Case Officer: Shona King

Proposal: Discharge of Conditions 2 (Schedule of materials), 3 (Samples of slate), 4 (stone sample panel), 6 (doors & windows), 7 (gable dormer details), 8 (ridge architectural details) and 11 (location of bat boxes) of 21/01254/REM

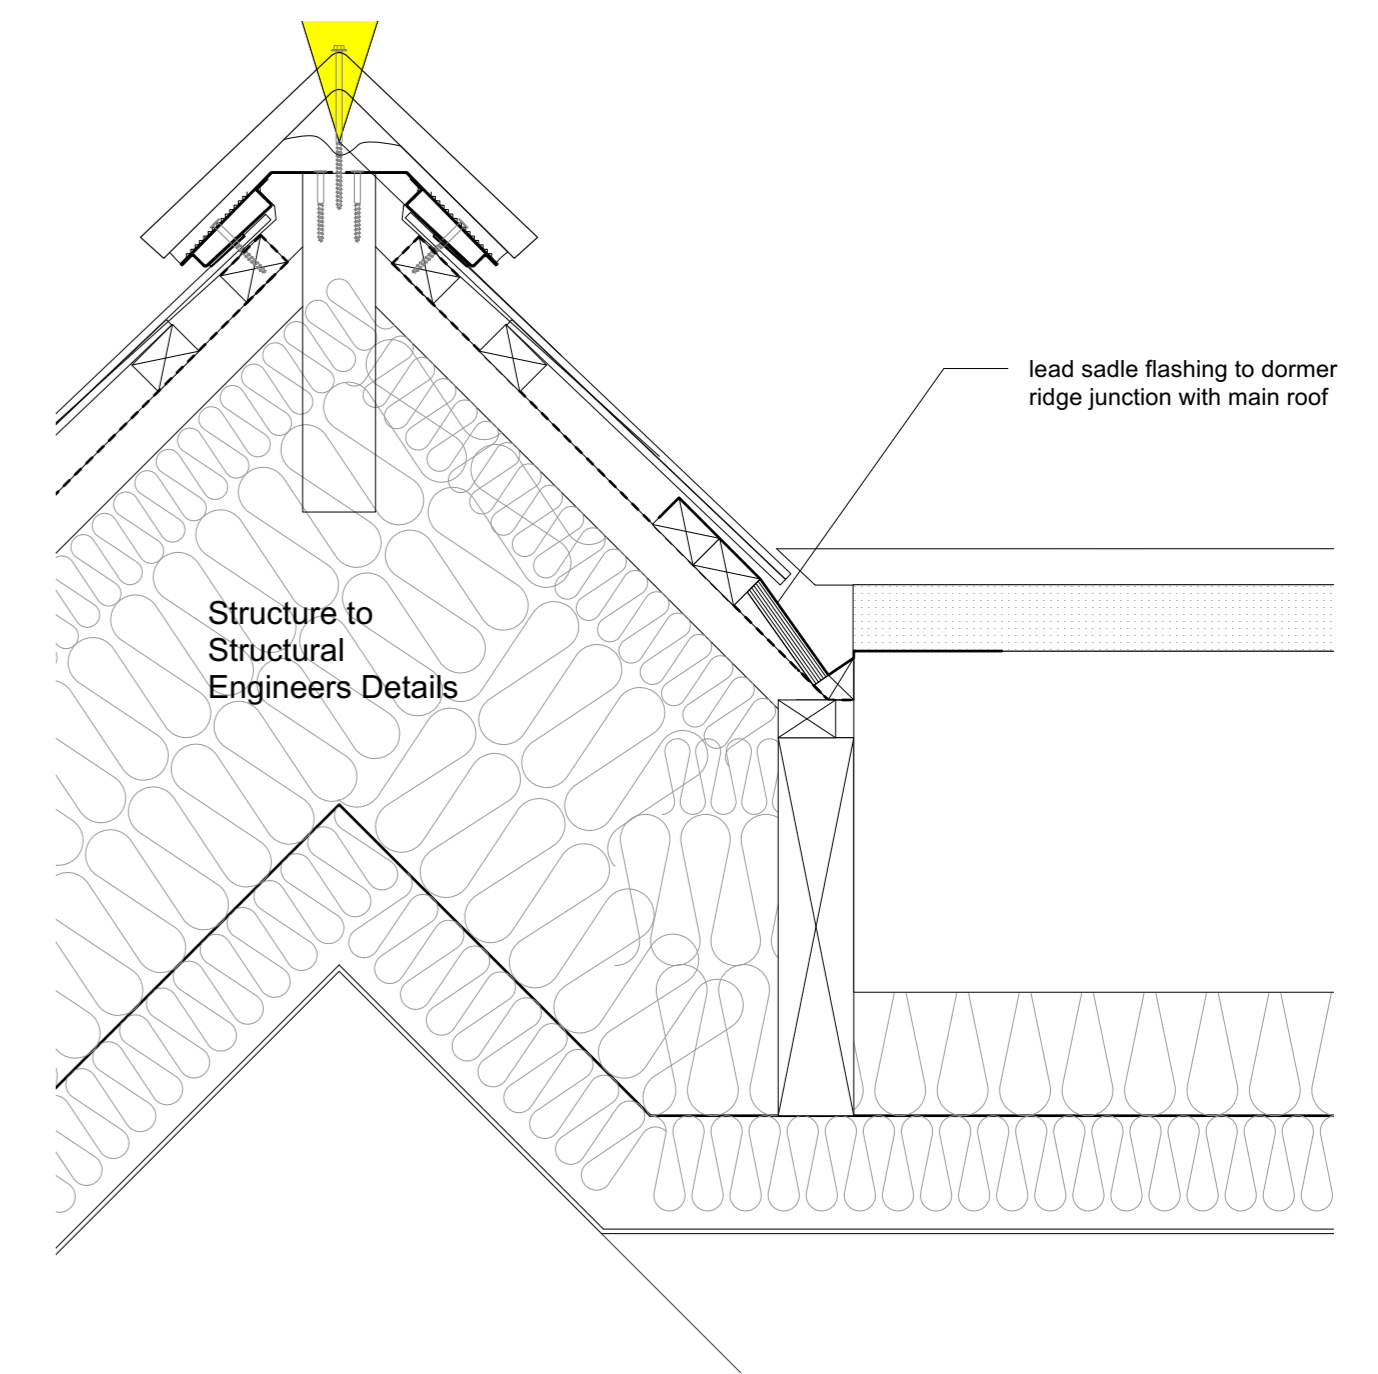
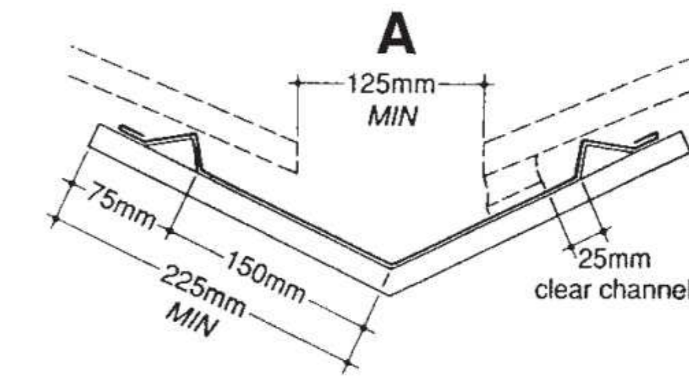
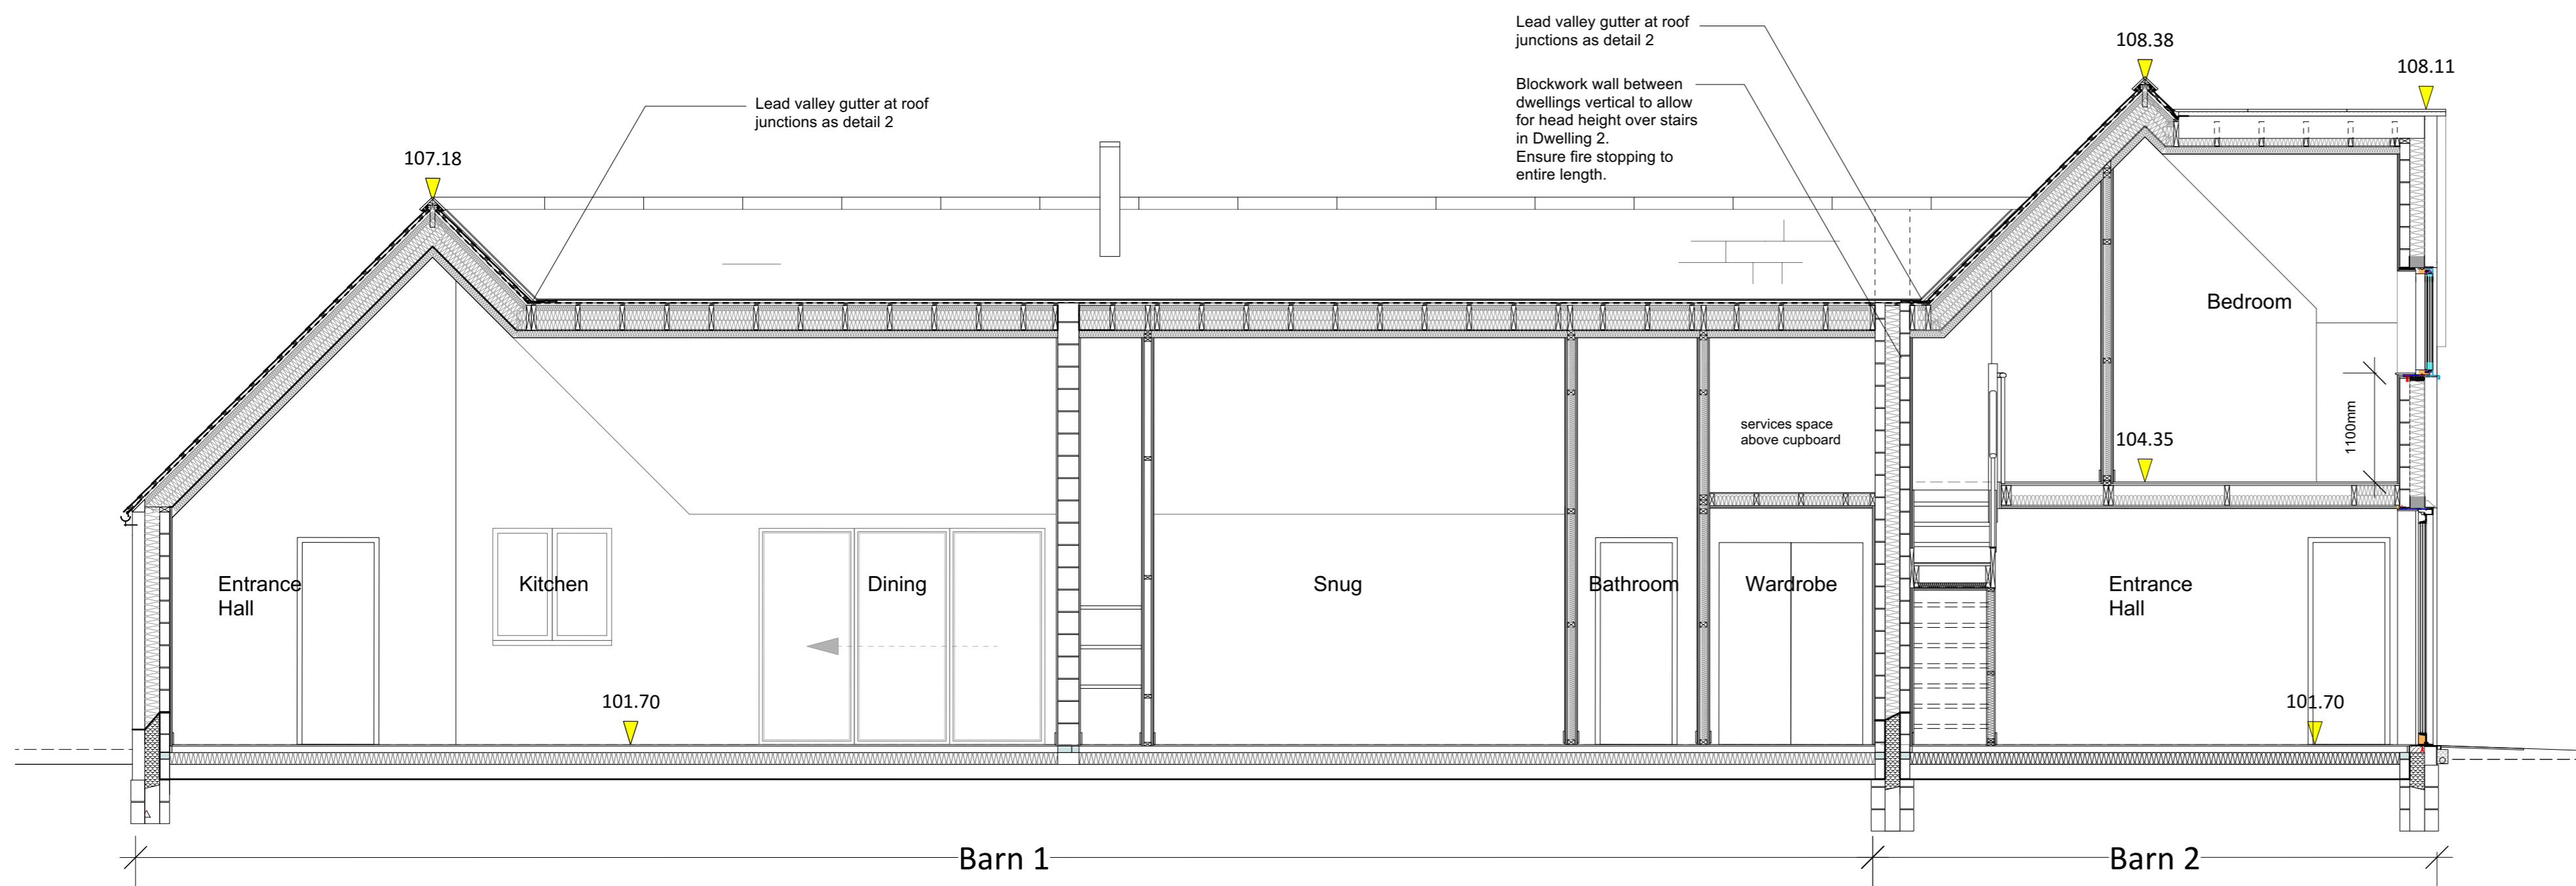
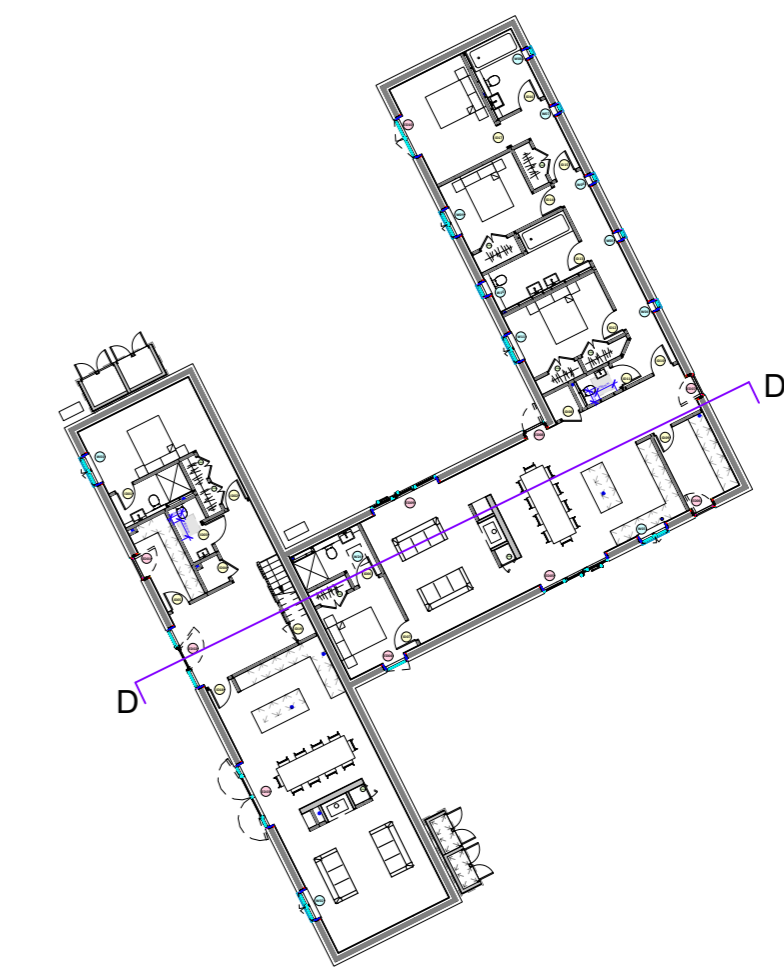
- 5.4. Condition 6 requires the approval of details of the doors and windows. The details that have been submitted are considered to be acceptable.
- 5.5. Condition 7 requires the approval of details of the gabled dormer. The details that have been submitted are considered to be acceptable.
- 5.6. Condition 8 requires the approval of the architectural detailing of the ridge and treatment of the eaves and verges. The details that have been submitted are considered to be acceptable.
- 5.7. Condition 11 requires the approval of a scheme for the location of bat boxes. The proposed bat boxes are suitable for the species found foraging and roosting and should constitute an enhancement in opportunities on site.

Condition 7

Drawing No. 21.02.04.16
